From: Anita Gardner
Sent: 21 March 2018 18:37
To: Karen Parsons
Subject: FW: FW: M/123/17/HH and M/133/17/PL - Little Thatch, 93 Middleton Road

The plans that you submit within the next two weeks will need to have professionally surveyed your property and your neighbours numbers 91 & 97 as they are currently built. This way the Location and Block Plans will show all these properties and I can confidently use them to accurately determine and highlight distances to the various boundaries/elevations. The plans (elevations and floor plans) submitted should be in existing and proposed form. They should include the existing first floor layout plan which is currently excluded from the application. They should be in colour and show all the detail that you are proposing for the extension for example detailing around the proposed windows/doors, tile hanging, highlight design features that draw on features found the locality., etc.

DRAWING 105
PROPOSED AND EXISTING
STREET ELEVATION
1:250
APRIL 2018

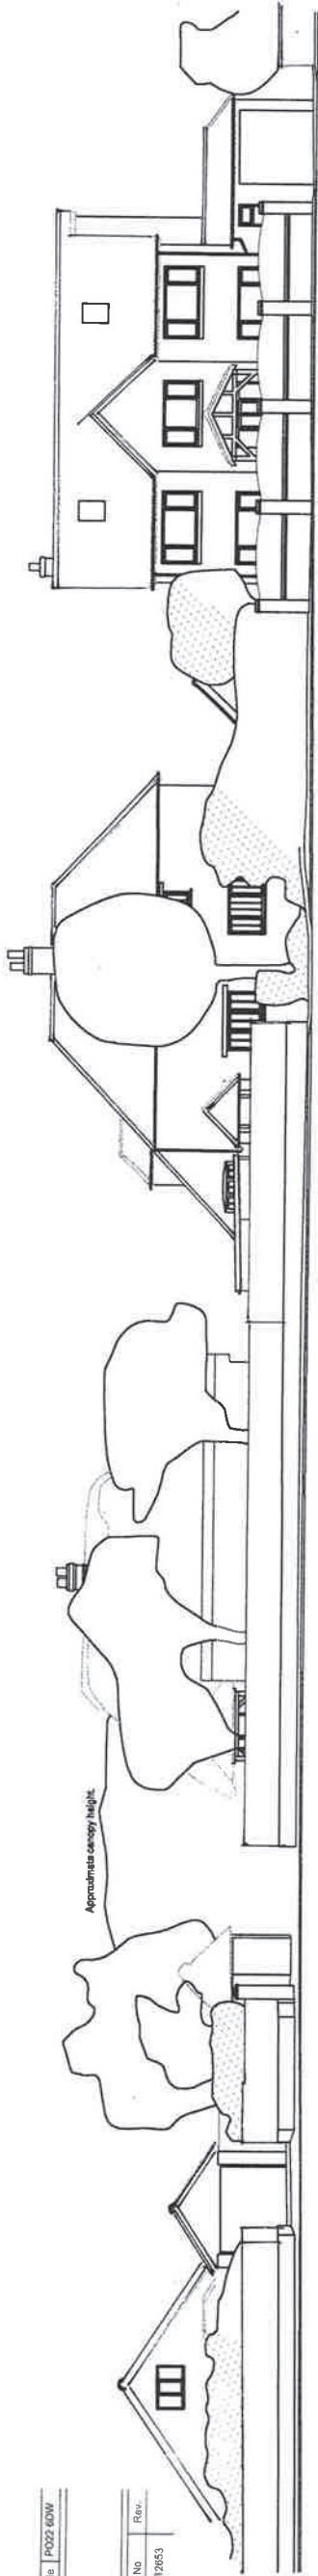
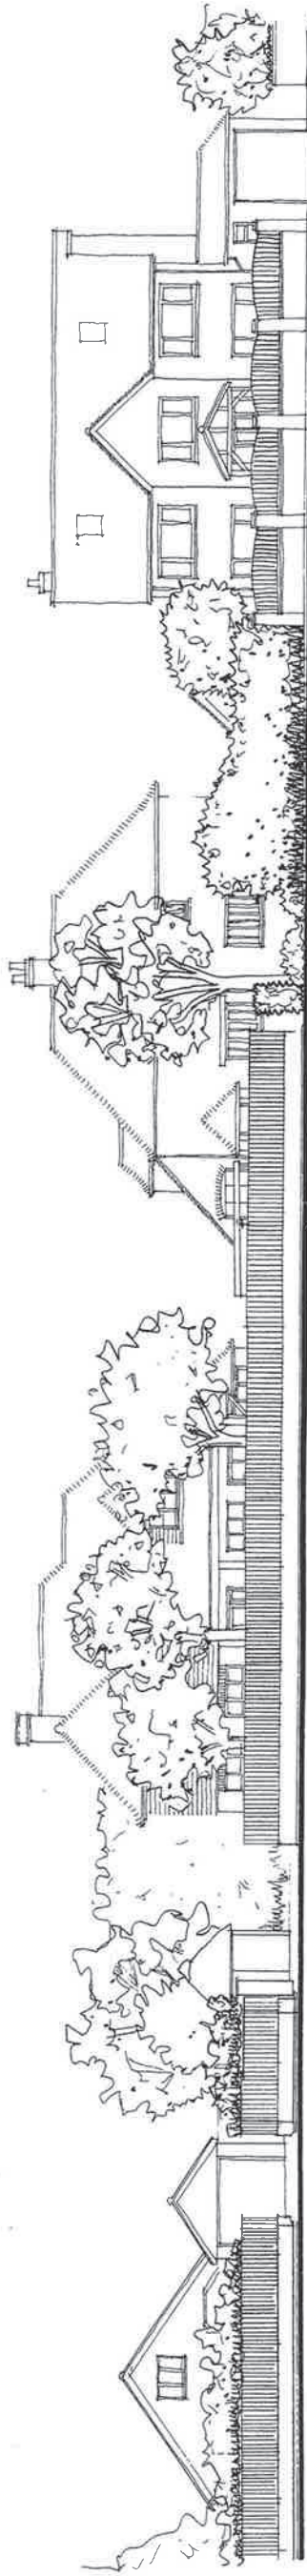
A plan is required to show the street scape so that it highlights your property in relation to neighbouring properties and a daylight/sunlight report/drawing in support of the application.
